From: Brenda Larsen
Sent: Tuesday, March 18, 2014 2:27 PM
To: Kaycee Hathaway
Subject: RE: Kittitas County Notice to Agencies BL-14-00007 Mynar

Re: Myner (BL-14-00007)

PROPOSED

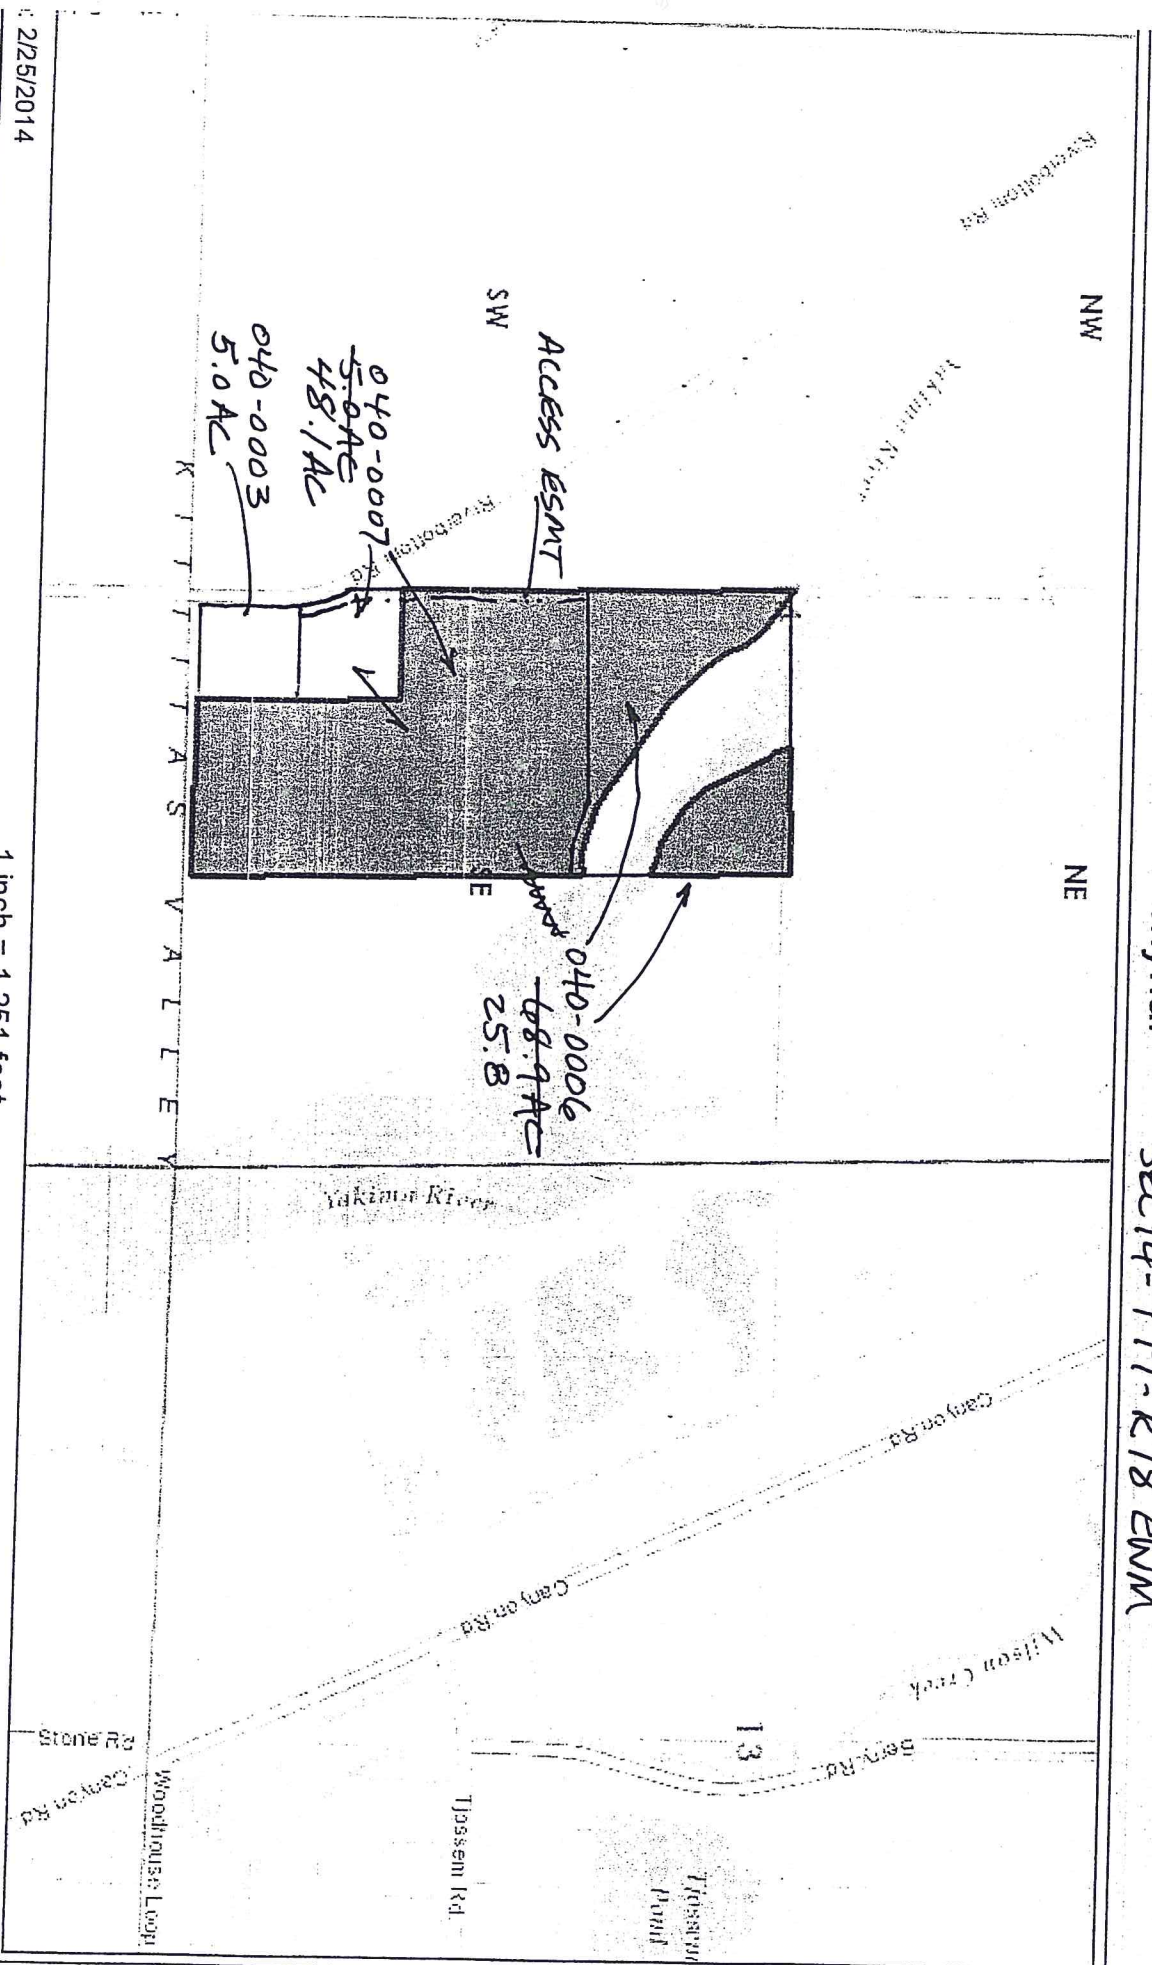
- Ensure that boundary line adjustments do not infringe upon existing structures, to include propane tanks, etc.
- Ensure adequate access for fire apparatus. Any driveways or access points created based off the new lot configurations shall comply with Kittitas County Code 20.02.030.
- All future development must comply with the International Fire Code.
